3. **Project# 1010299**
15DRB-70320 MINOR - PRELIMINARY/
FINAL PLAT APPROVAL

ARCH + PLAN LAND USE CONSULTANTS agent(s) for GERALD ORTIZ Y PINO, DONNA & LAURA BRUZZESE request(s) the above action(s) for all or a portion of Lot(s) A & B, Block(s) 11, **PEREA ADDN** zoned SU-2/DNA-SF, located on NE CORNER OF ROMA & 13TH ST containing approximately .22 acre(s). (J-13) **THE PRELIMINARY/FINAL PLAT WAS APPROVED WITH FINAL SIGN OFF DELEGATED TO PLANNING FOR AMAFCA SIGNATURE.**

DRB CASE ACTION LOG - BLUE SHEET

PEREA ADDN

PLAT OF LOTS A-1 AND B-1, BLOCK 11 PEREA ADDITION

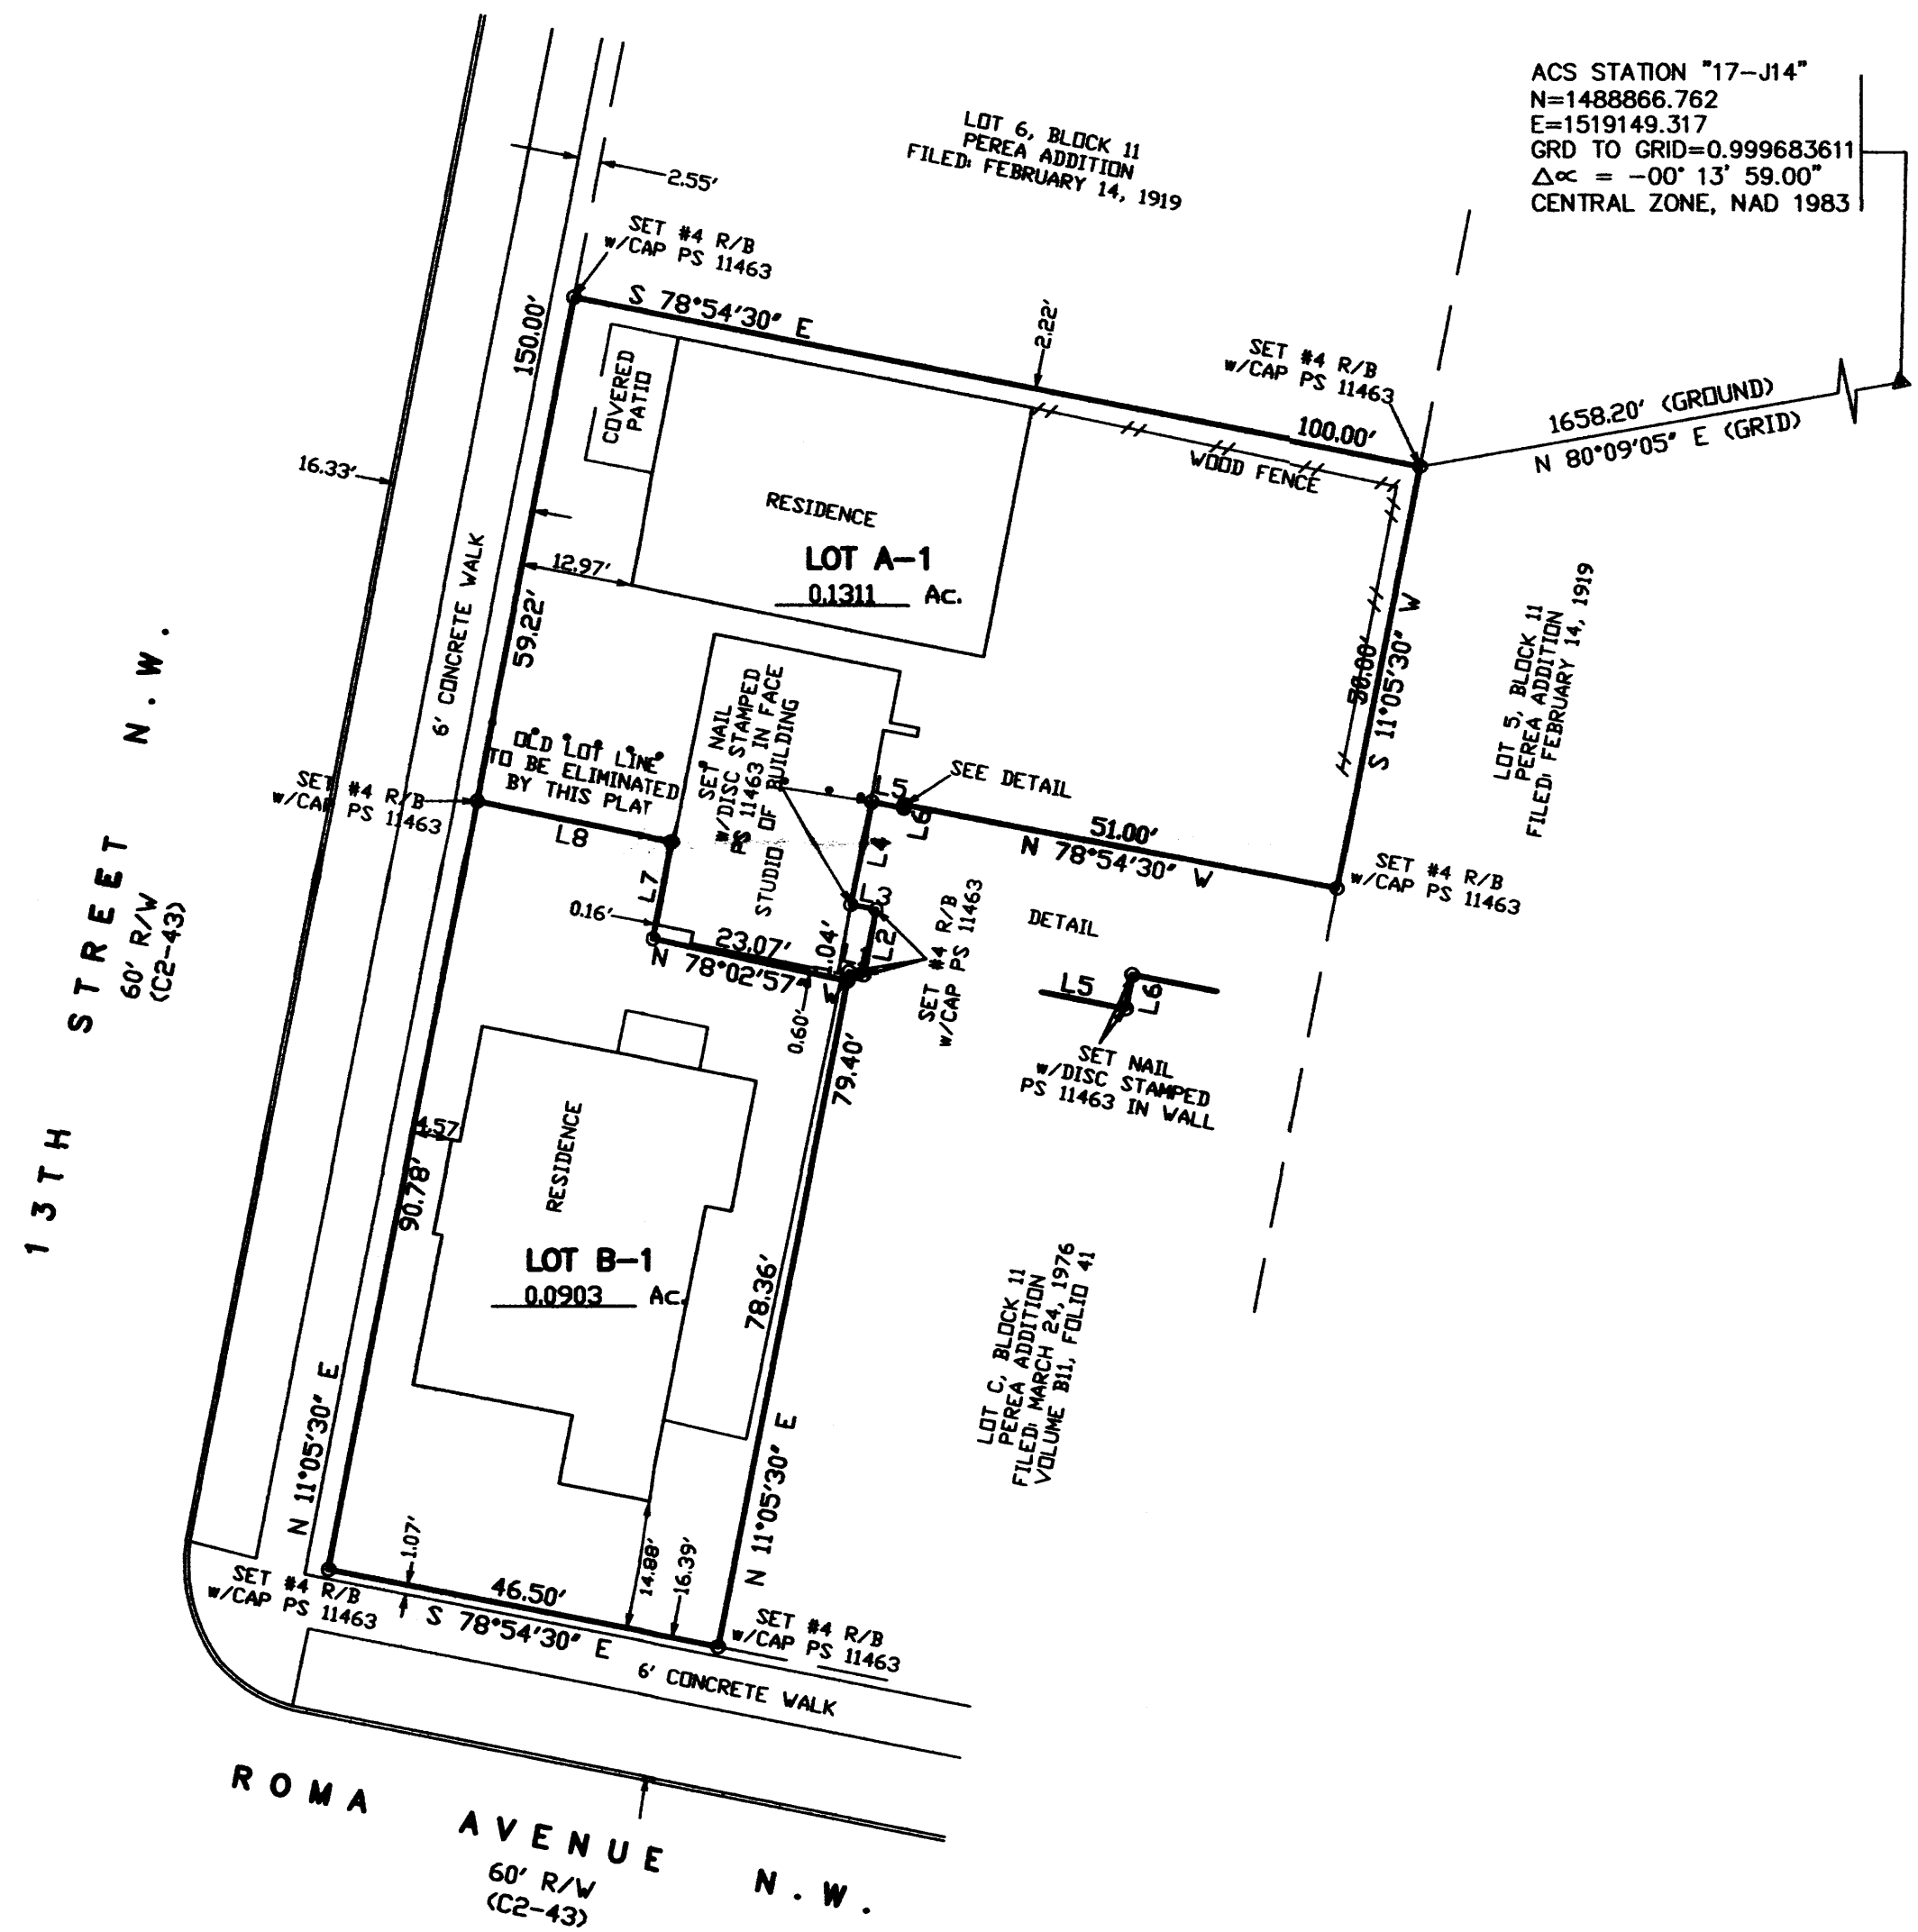
Conformance with Planning and Zoning is required in Section 14-14-2-2 of the Subdivision Regulations, which means a variance will be required for Lot B, Block 11, which is only 4,200 square feet (min. lot area requirement is 5,000 square feet), and for parking since off-street parking is being lost.

The property owner secured lot size variance subject to 15ZHE-80007 and a parking variance subject to 15ZHE-80006 in February 2015.
